Your Ref: OWPC18234
Our Ref: FG/45/18/HH 11-03-2018
Please ask for:
Pat Aird

Single storey front, side & rear extensions (resubmission following FG/92/17/HH).
25 Upper West Drive Ferring

Thank you for your internet representation made on 14th May 2018 which has been recorded as '**an objection**' with the comments as follows:

Drawing No.
1336/P02

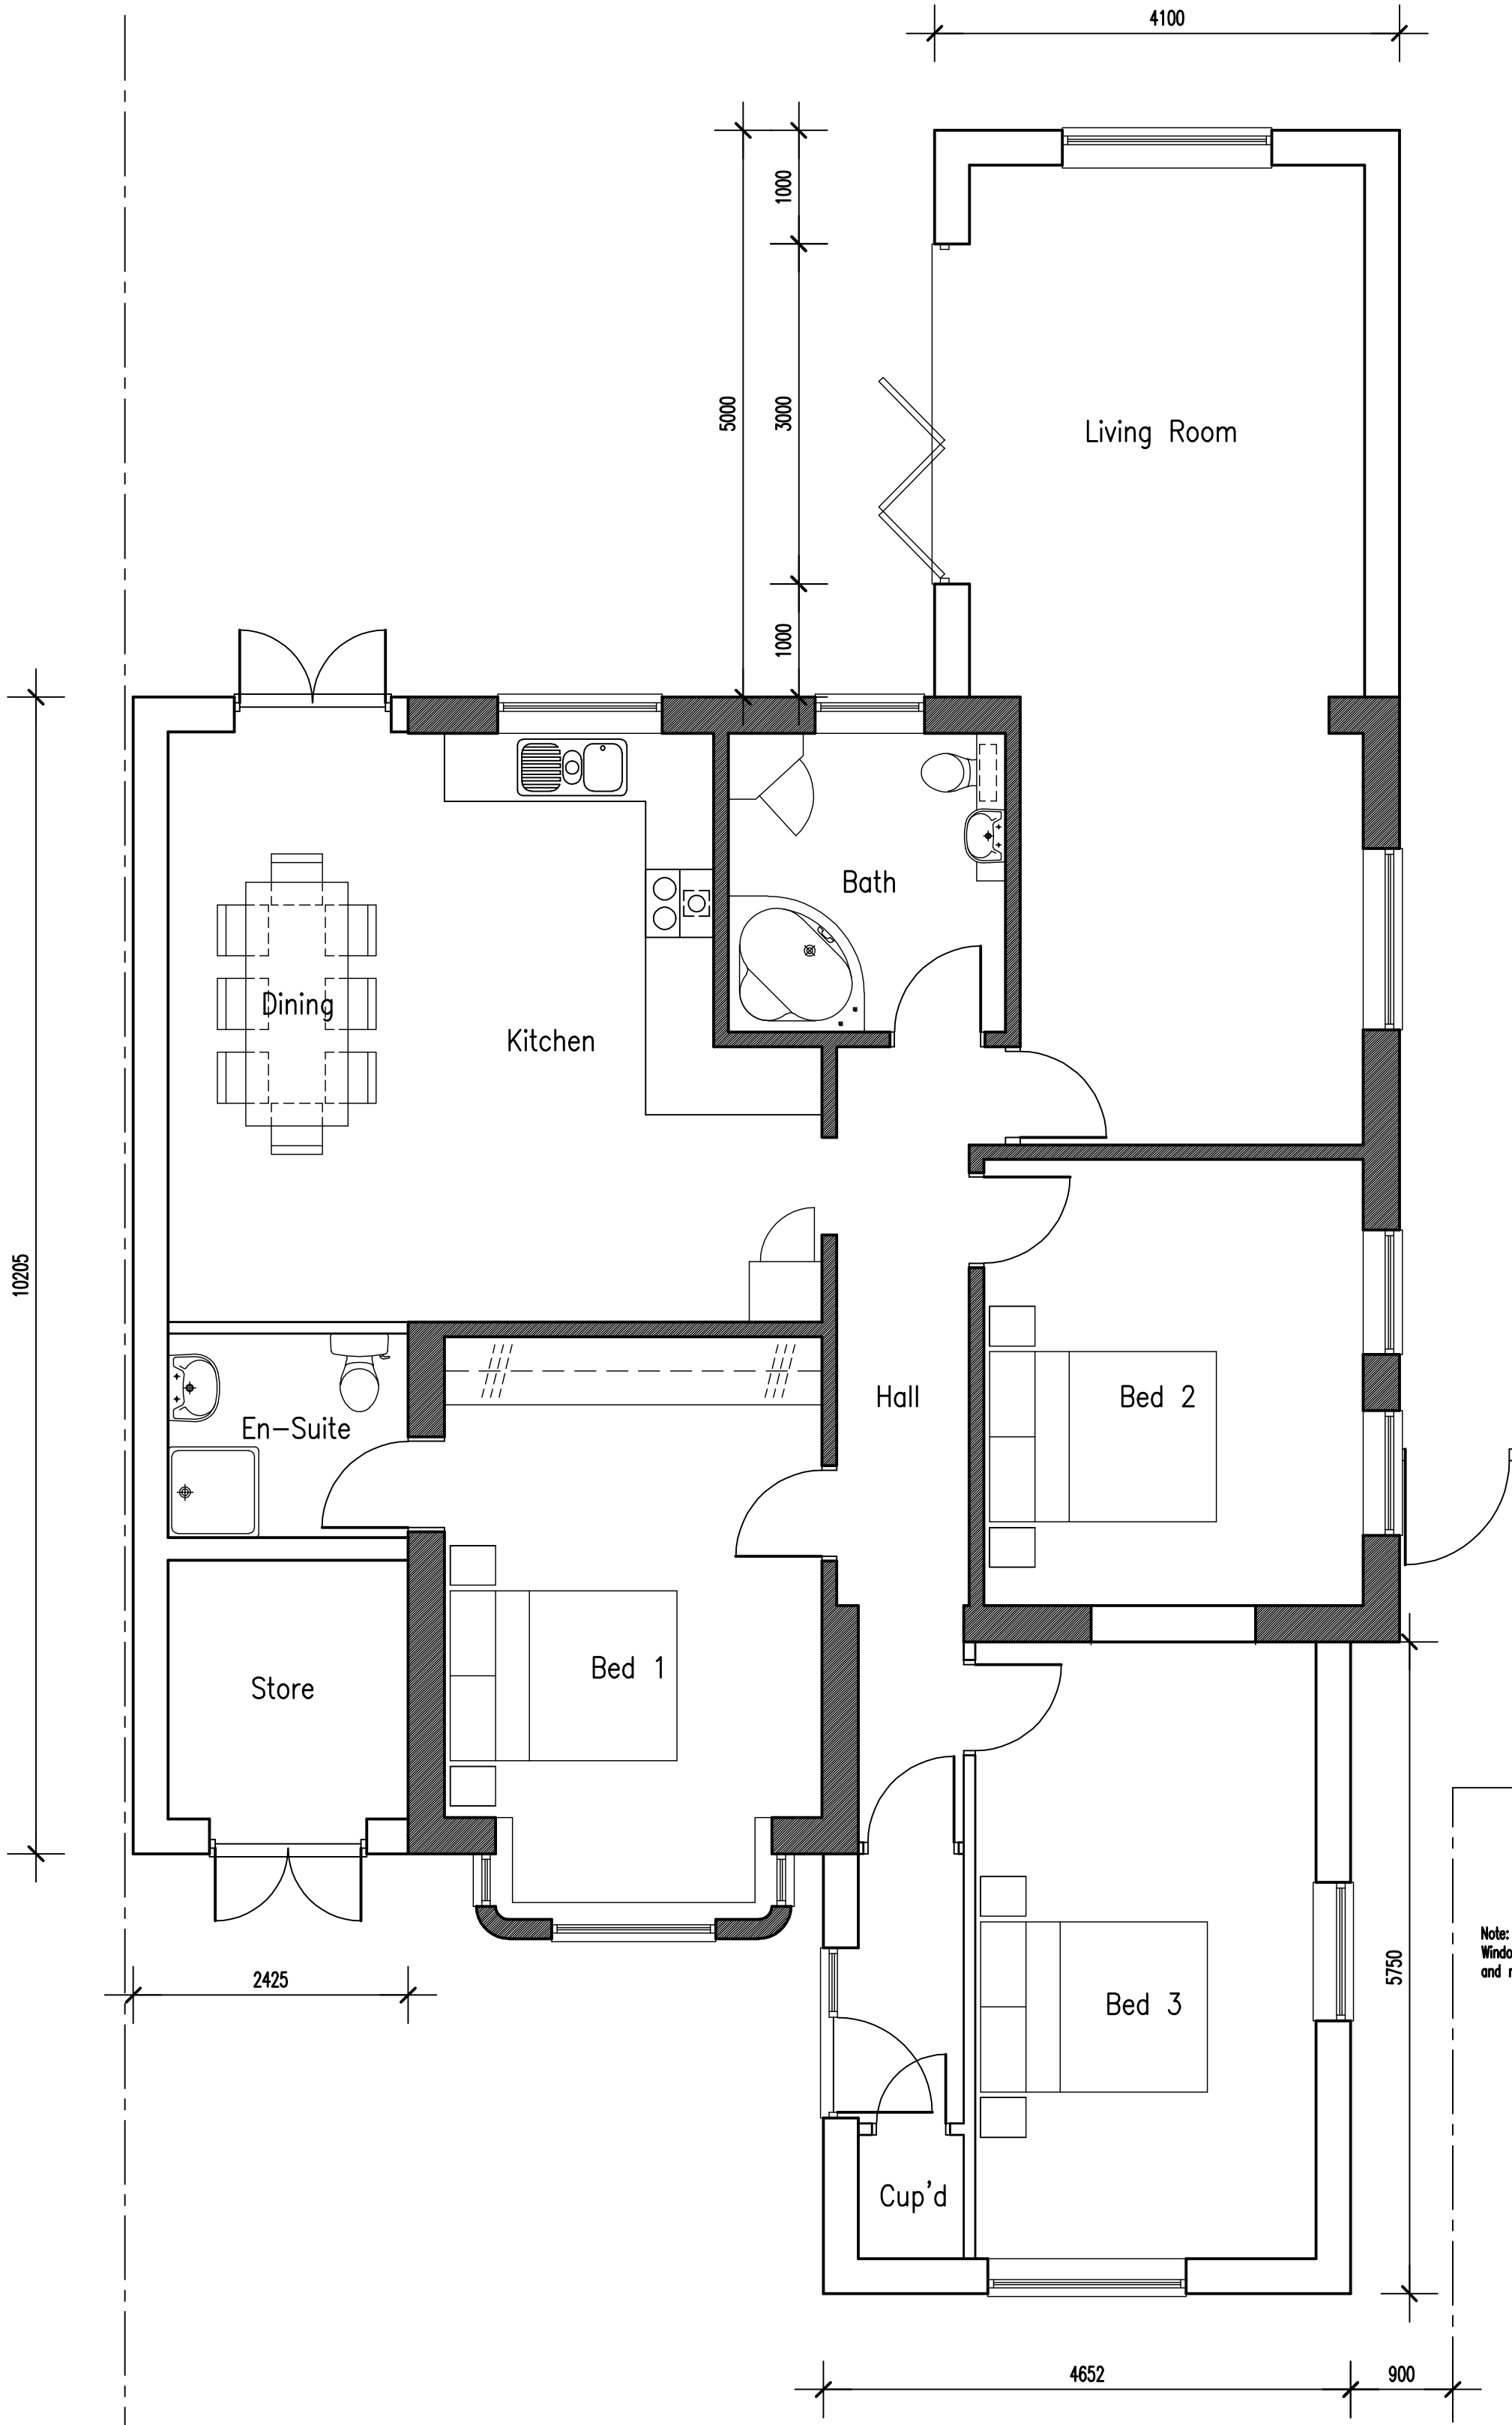
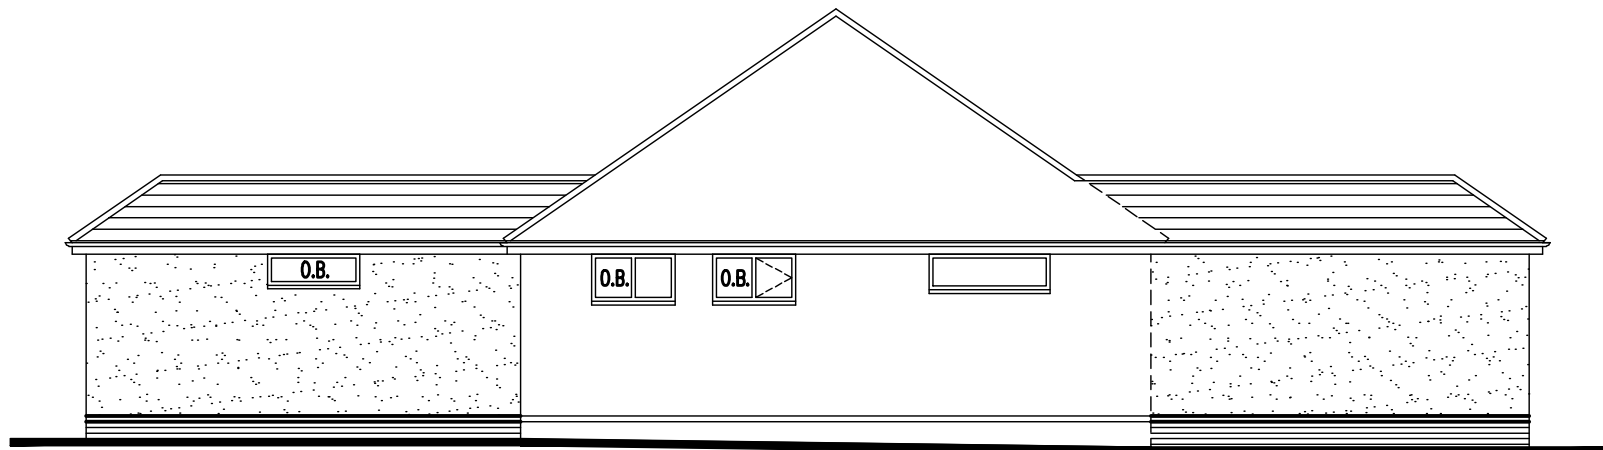
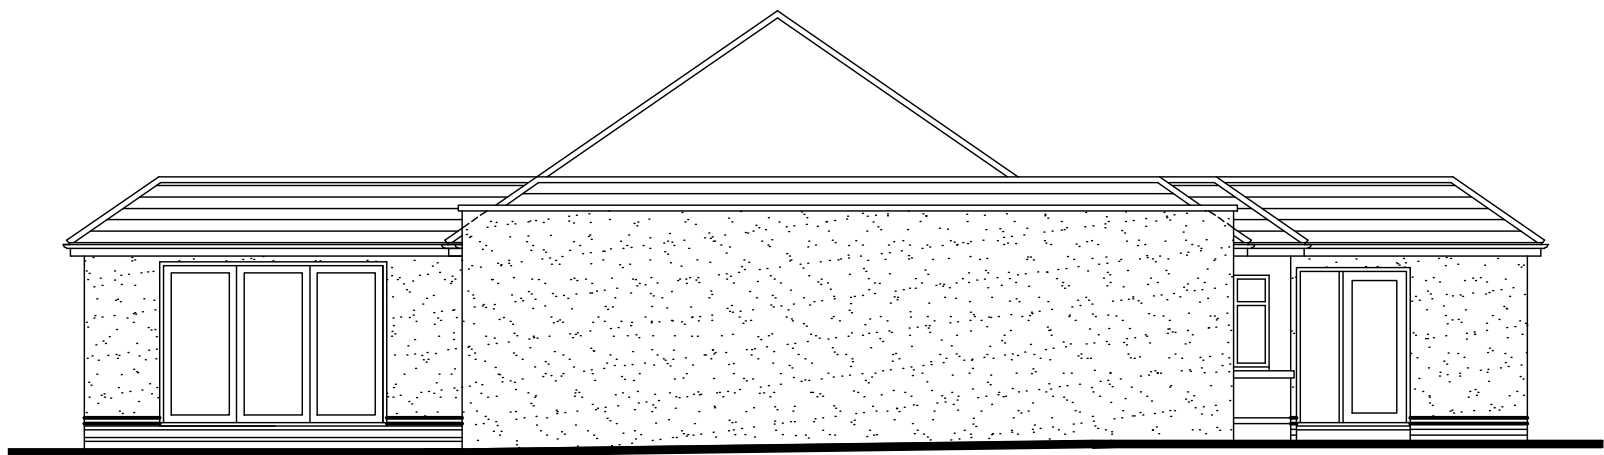
The windows in bedroom 2 are shown in the application as opaque with the window towards the front of the property fixed. The installed windows both have openings allowing direct view into my mothers bedroom.

The cill level is lower than the original plan which means my mothers bedroom is directly overlooked. My brother spoke to the builder and from standing at floor level could easily see into my mother's bedroom, he is 5' 7" tall.

The glass is not opaque enough, my mother can see people easily on the other side of the glass.

The main issue is the window towards the front of the property as it overlooks us. We have no objection to the window towards the rear being larger if light is an issue.
